CITY OF ALBUQUERQUE

November 8, 2016

**RE: Lot 18A Block 2 Unit 19 Volcano Cliffs Subd.
7700 Compass Dr. NW
Request for Permanent C.O. - Accepted
Engineers Stamp Date 10/26/15 (D10D003G18A)
Certification Dated: 11/7/16**

**GRADING AND DRAINAGE PLAN**  
**LOT 18A, BLOCK 2, UNIT 19, VCS**  
**ADDRESS: 7700 Compass Drive NW**

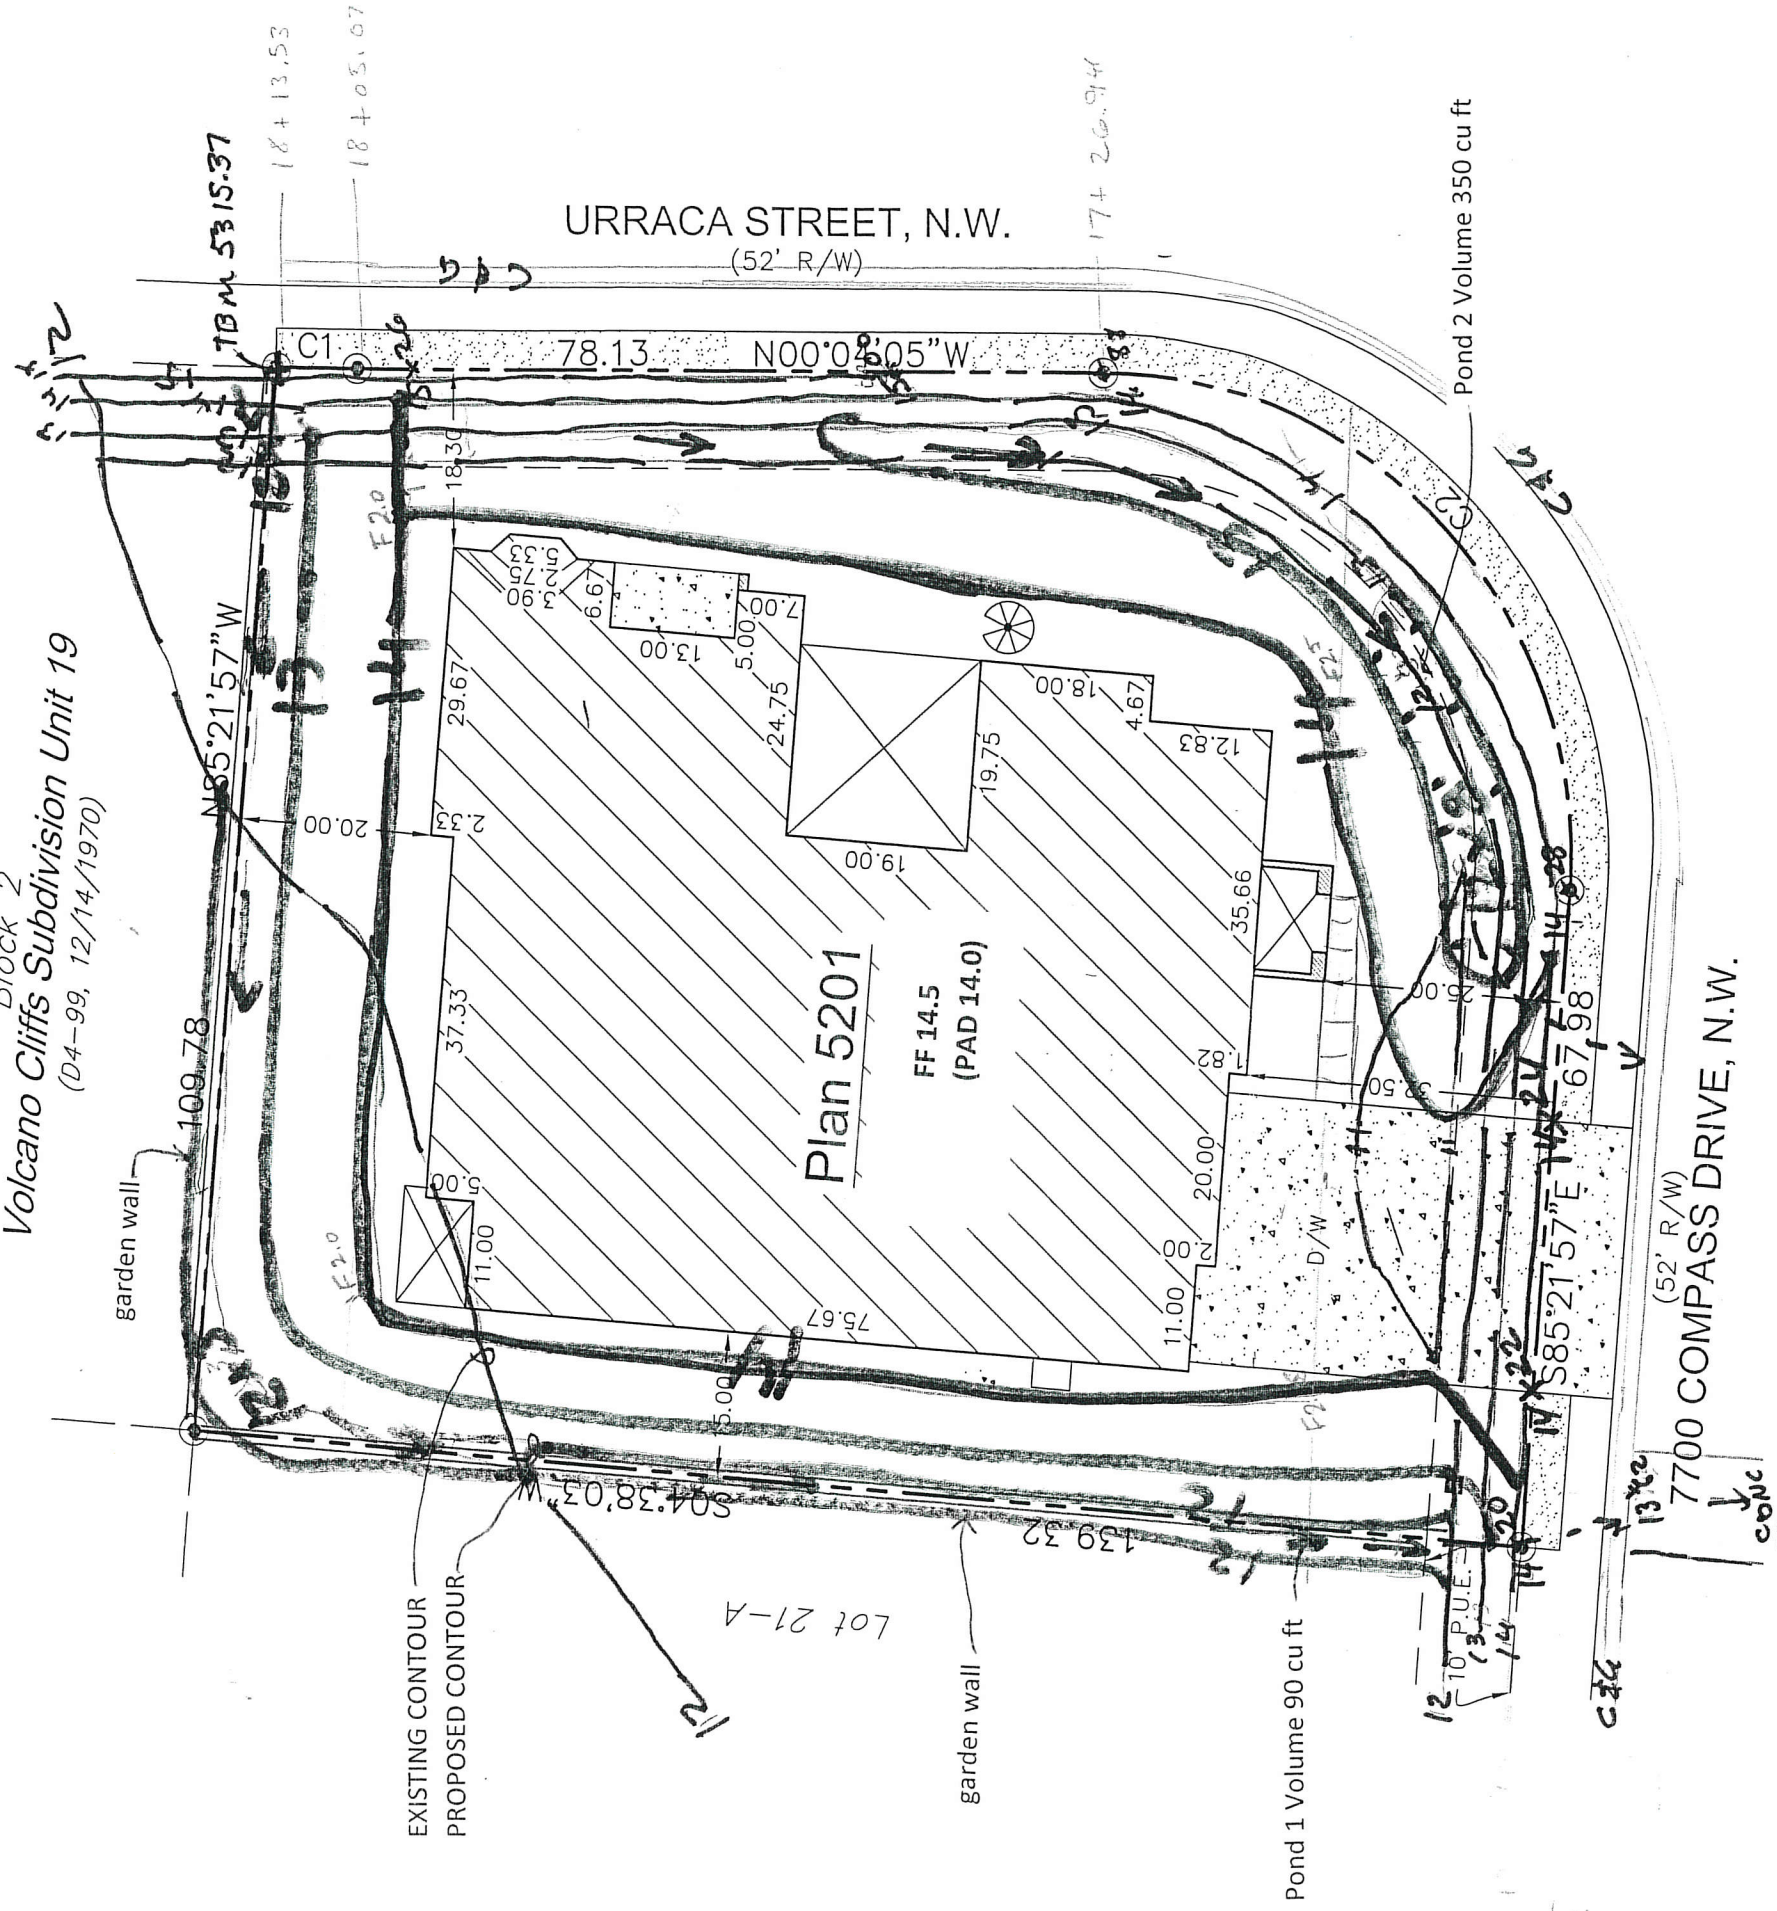
Based on the Certification received 11/7/2016, the above mentioned residence is acceptable for release of Certificate of Occupancy by Hydrology. The pond in the backyard was designed to be further away from the residence. Recommend moving the pond further to the SW corner as indicated on the approved grading and drainage plan.
